Recommendation Report for Planning Permission for Works or Extension to a Dwelling

REF NO: FP/60/20/HH

LOCATION: 9 Ferndown Gardens
Felpham
PO22 8JL

PROPOSAL: Single storey front extension.

Drawing P01 March 2020 Scale 1:100 / 1:500 / 1:1250 @ A3
Planning Drawing - Plans, Elevations, Block & Location Plan

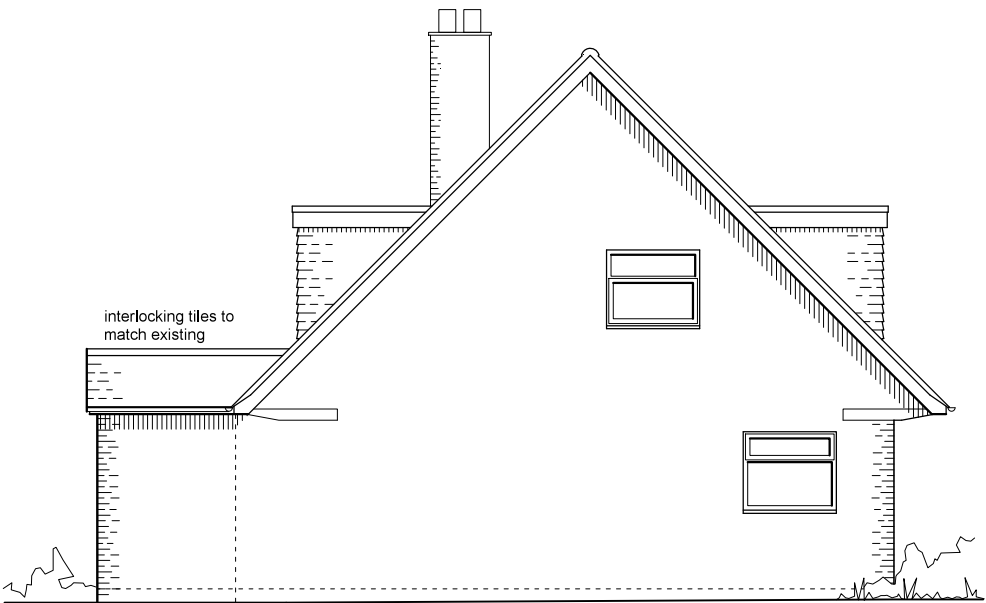
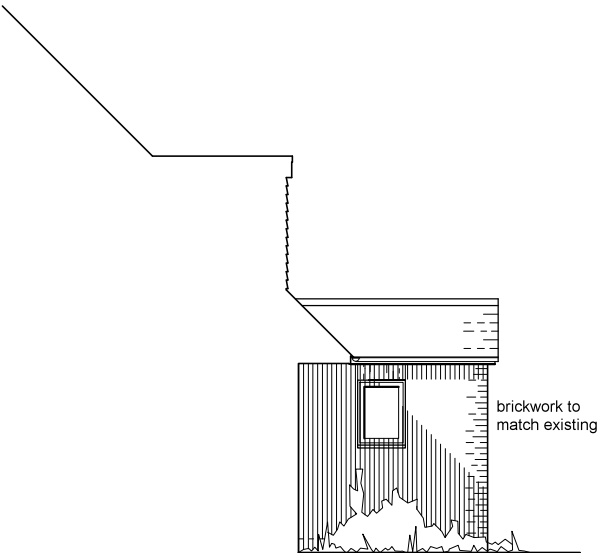
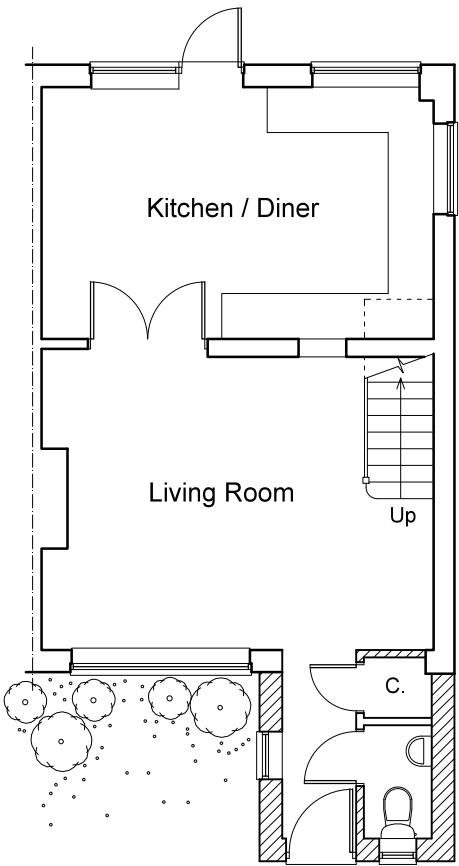
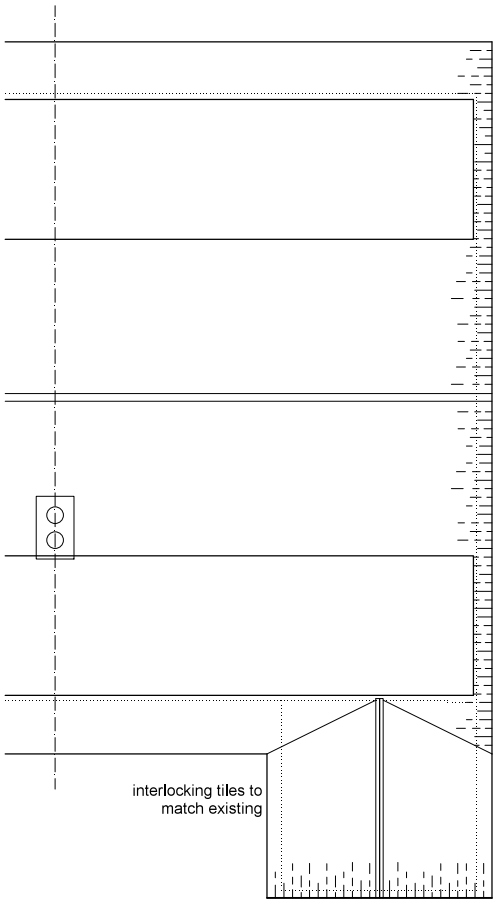
The extension will have a depth of around 2.5m with a height of 3.25m with a pitched roof. Eaves will match the existing dwelling. Whilst this adds bulk to the front of the property, it is not considered to appear as an unduly dominant feature to the front elevation.

The porch would reduce the ability to park at the front of the property however there is sufficient space to the side of the dwelling for 2 cars.

Due to the siting of the porch to the principal elevation it is not considered to give rise to adverse overbearing or overshadowing impacts retaining 2.5m and 3m to the side boundaries.

There will be a window to the northern elevation, however any views are not considered additional to that which can already be achieved and will be of the street scene.
